**Application by Highways England for an Order Granting Development Consent for the A38 Derby Junctions Scheme**  
**The Examining Authority's issues and questions for Issue Specific Hearing 2**  
**Issued on 3 December 2019**

Summer

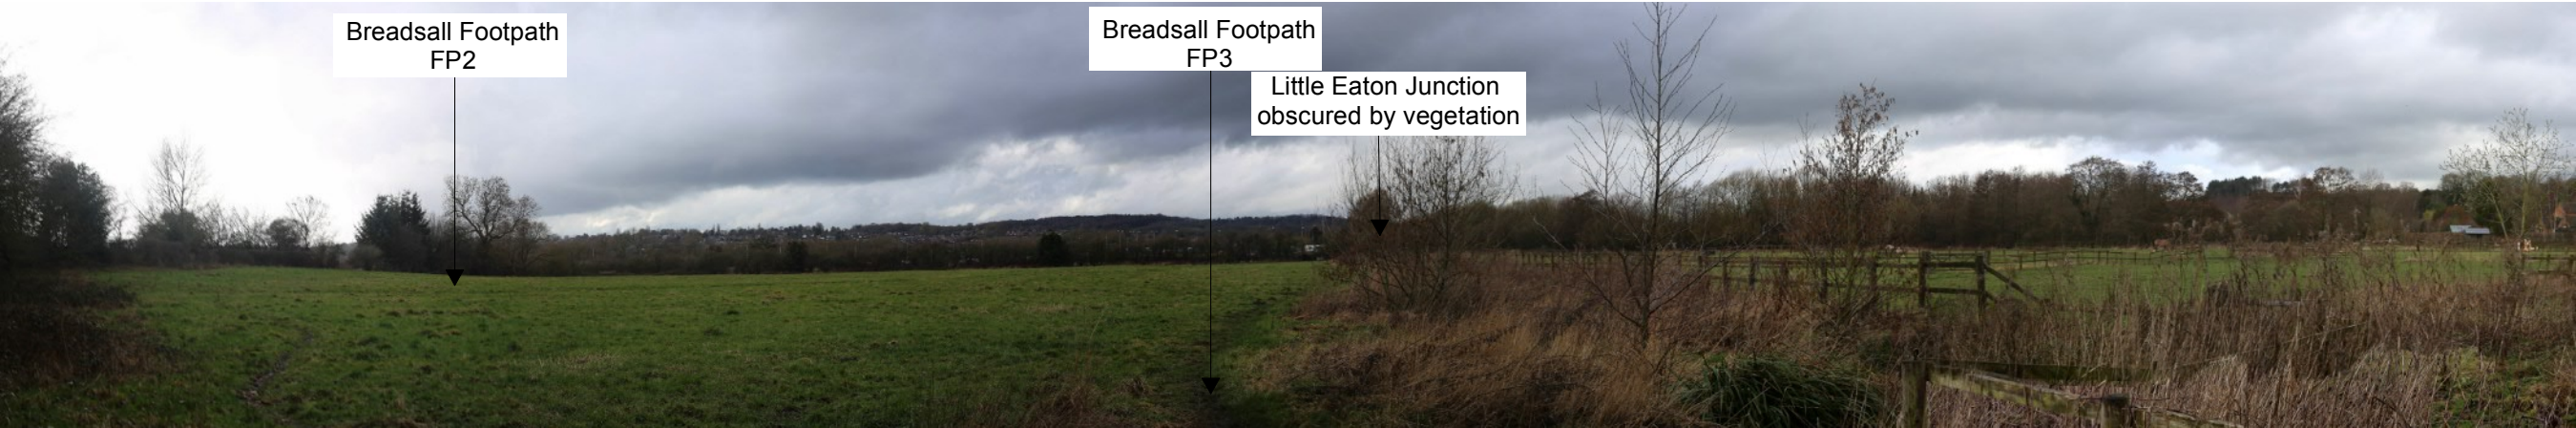
28.	<p>Whether the methodology used in the landscape and visual assessment properly reflects the impacts of the proposals ExA issue / question [PD-003] Q9.1, Q9.7 Applicant response [REP1-005] DCC response [REP1-030] DCiC response [REP1-034] ES Figure 7.5a [REP2-011] Additional Photomontages [REP2-021]</p>	<p>a) Update on the additional photomontages based on the North Avenue Inquiry. Issues, outcome and relevance of that Inquiry. b) Do the revised representative viewpoints and new photomontages allow the landscape and visual impacts of the proposal to adequately assessed?</p>
